October 16, 2018

Project Name: **Capisic Meadows 8 Lot Subdivision**
Project ID: Subdivision and Site Plan: # PLO00092-2018
Address: 130 Bancroft Street, Portland CBL: 193 E 019/025/026/039
Applicant: W B Group, Inc.
Planner: Jean Fraser

PLAN CORRECTIONS REPORT PL-000092-2018 FOR CITY OF PORTLAND

Drawing file: Drawings / 41041 Subdivision 5-01-2018.pdf

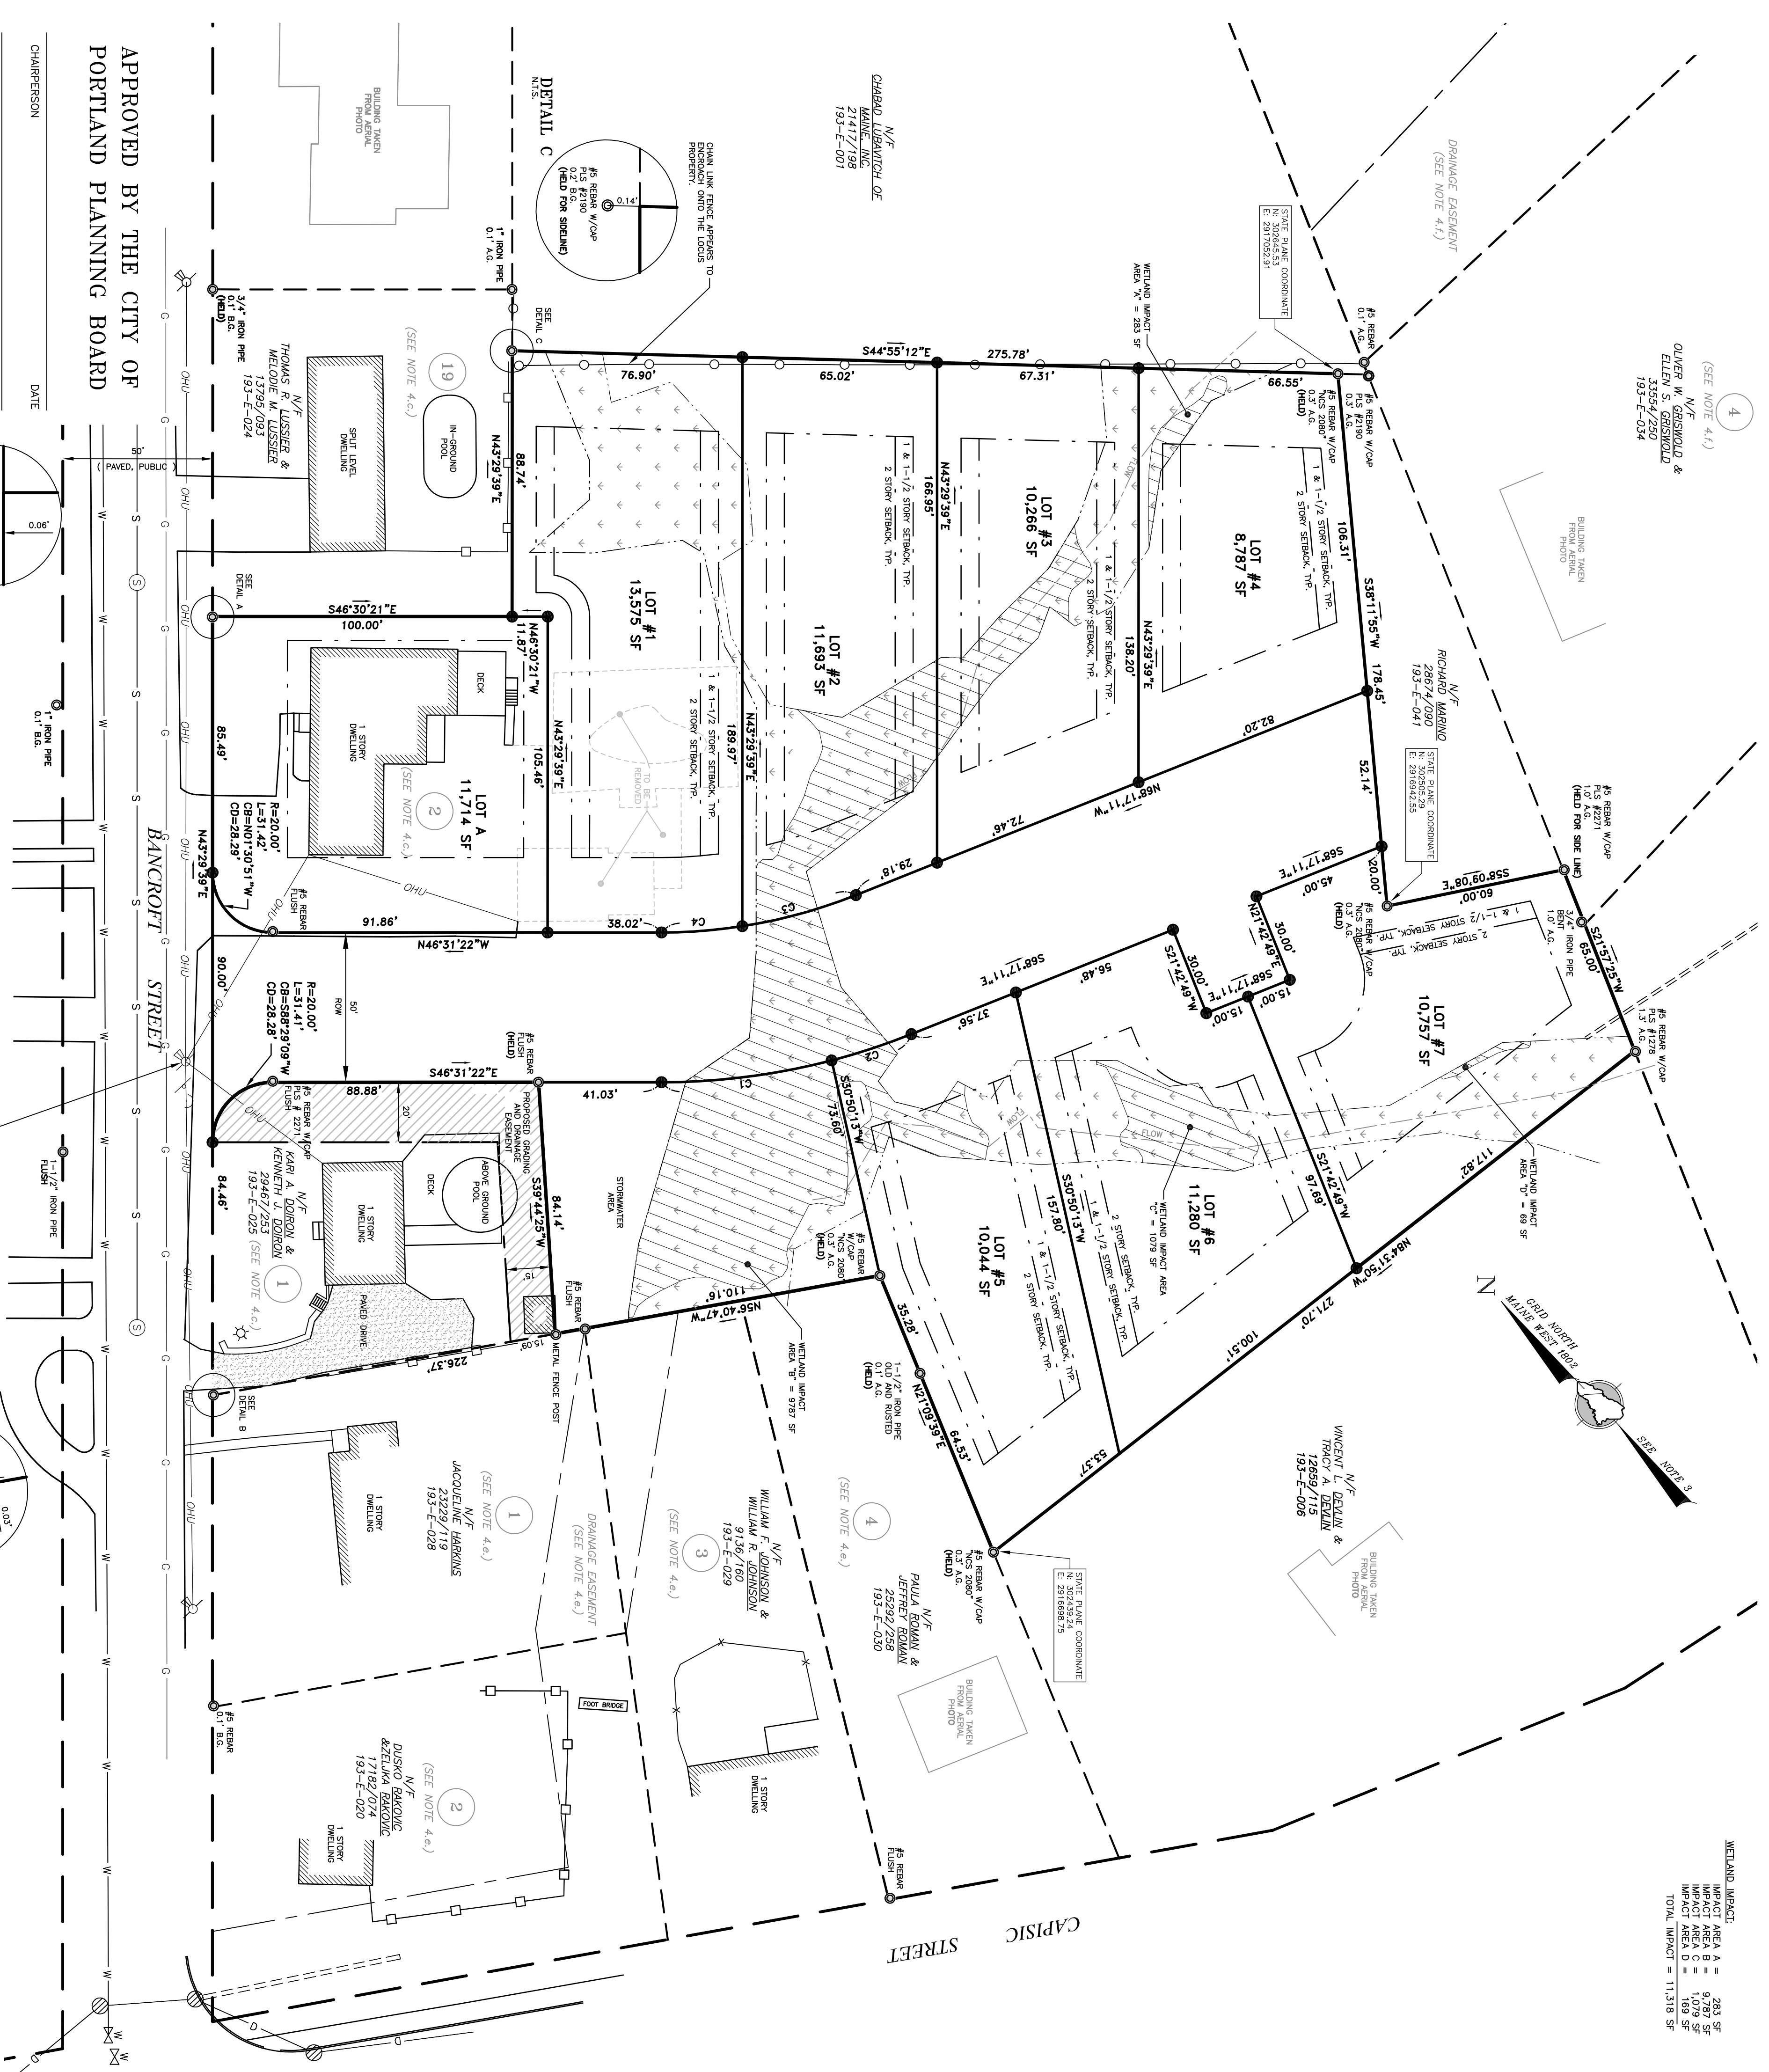
1. I assume that this is going to be offered to the City as a public street. If that's the case:
 - a. An elevation benchmark shall be established on at least one of the new street monuments, and it shall be shown and described on the As-built Plan for this project;.

- b. At least two of the new street monuments shall be labeled with state plane coordinates on a revised copy of the Subdivision Plan.
2. Does the new street have a name yet? If so, please add it to the plan.

3. There should be a note added to the plan to identify who's responsible for the storm water maintenance agreement, and stating that the agreement will be recorded in the Registry of Deeds.

4. A monument needs to be added at the PC on the proposed street in front of Lot A. It will replace an existing rebar that 's shown on the plan.
5. I spoke with John Perron at NCS earlier this month about the monument locations. I suggested installing all of them on the street line instead of on three-foot offset for this project.

CROSS SECTION OF EMERGENCY SPILLWAY
NOT TO SCALE

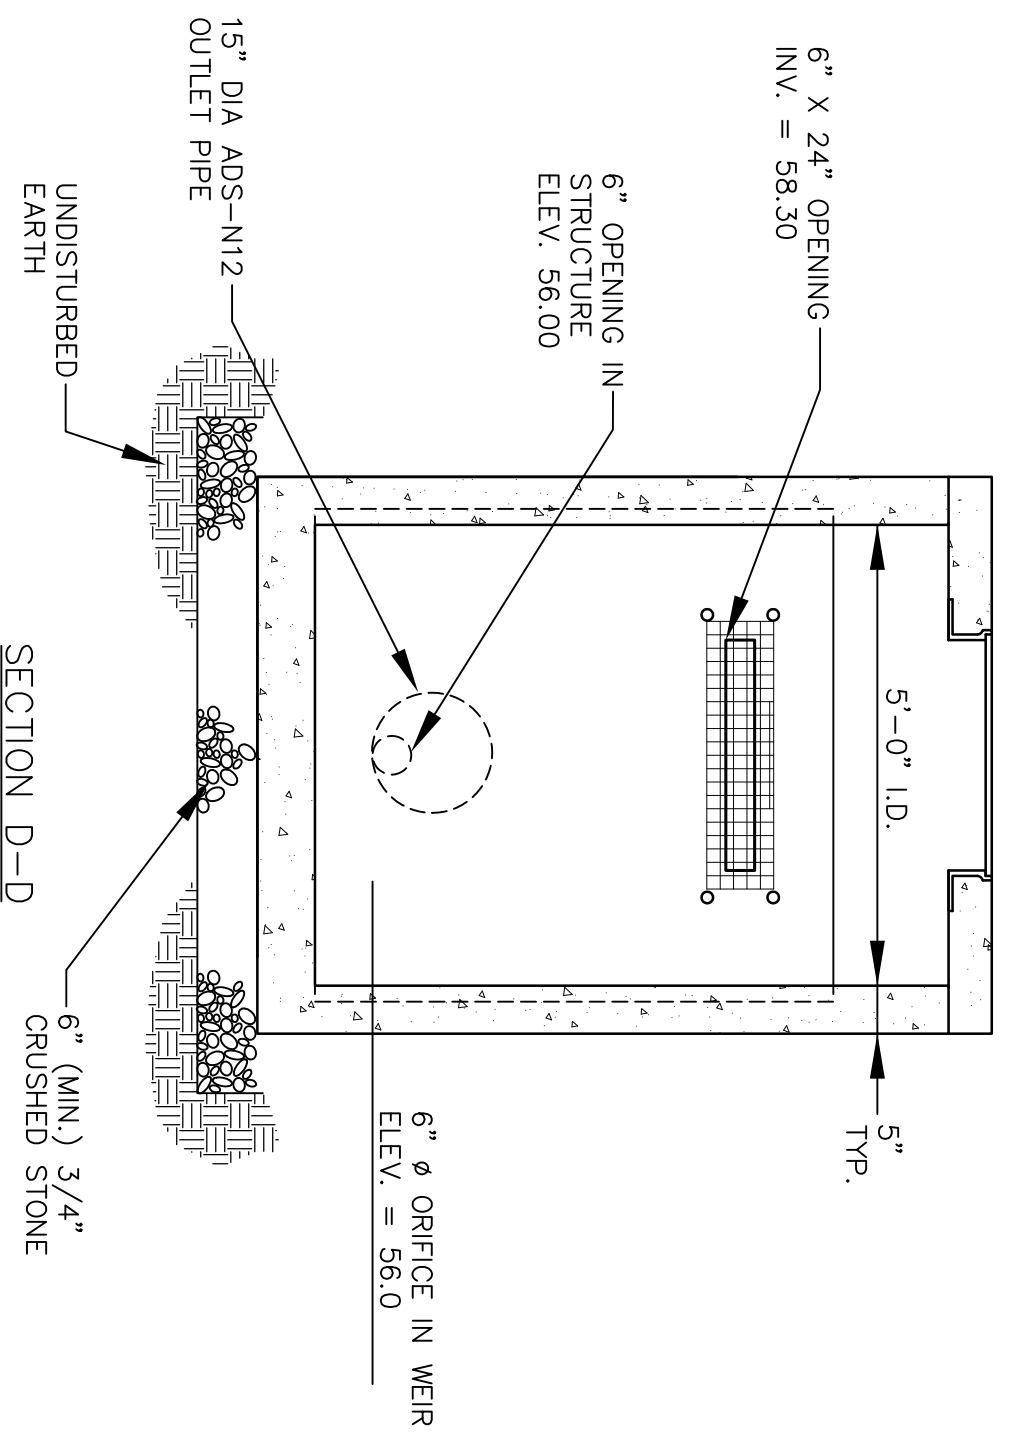
The Grading and Drainage Plan indicates that SD-7 will be a 15-inch pipe, but the HydroCAD model indicates that it is 18-inches. The dimensions of the emergency spillway are also inconsistent between the plans and the model.

Corrective Action: The Applicant should clarify and ensure that the drawings and the model are consistent.

PRESSURE TREATED WOOD GUARDRAIL

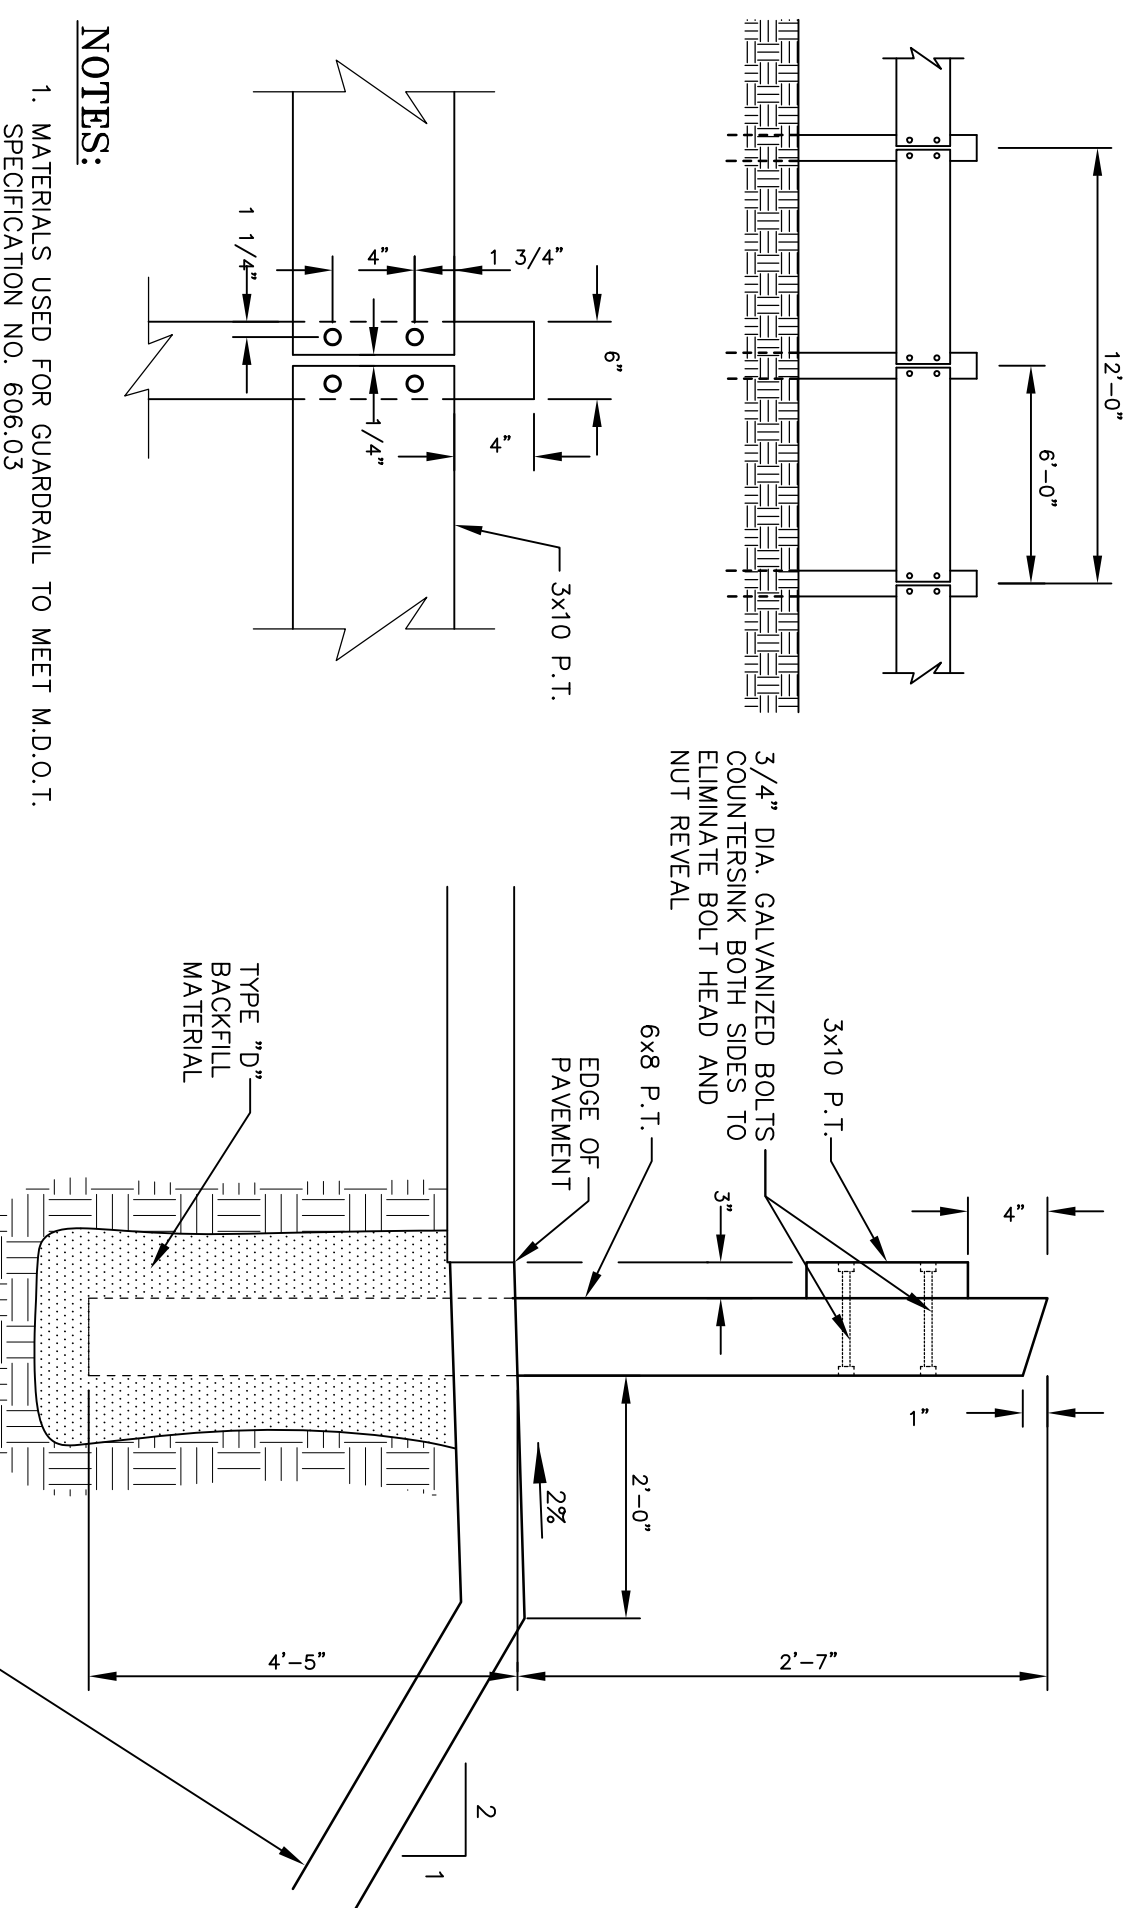
- c. To propose options for a more attractive fence around the detention basin;
 - d. To revise the street turnaround to include “no parking” signs;
 - e. To revise the new street to extend the paving to the end of the ROW without the proposed guardrails;

TYPE "B" UNDERDRAIN INSTALLATION DETAIL - ALTERNATIVE "A"

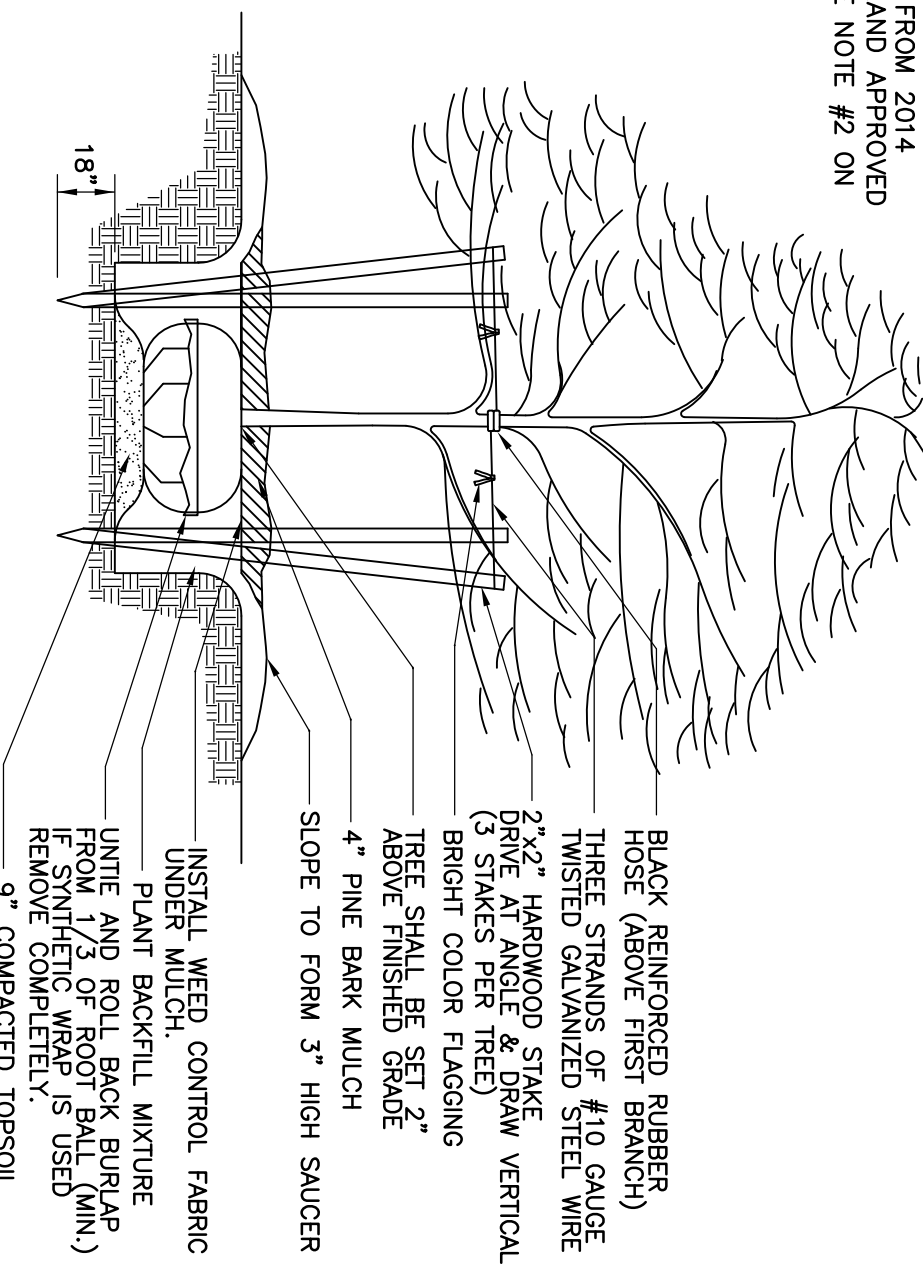
Proposed details include a "Type B Underdrain Installation Detail – Alternative A" that shows underdrain along the roadside edge under curbing; however, the proposed grading and drainage plan does not show locations or discharge points for proposed underdrain.

Corrective Action: Clarify the use of underdrain on the site.
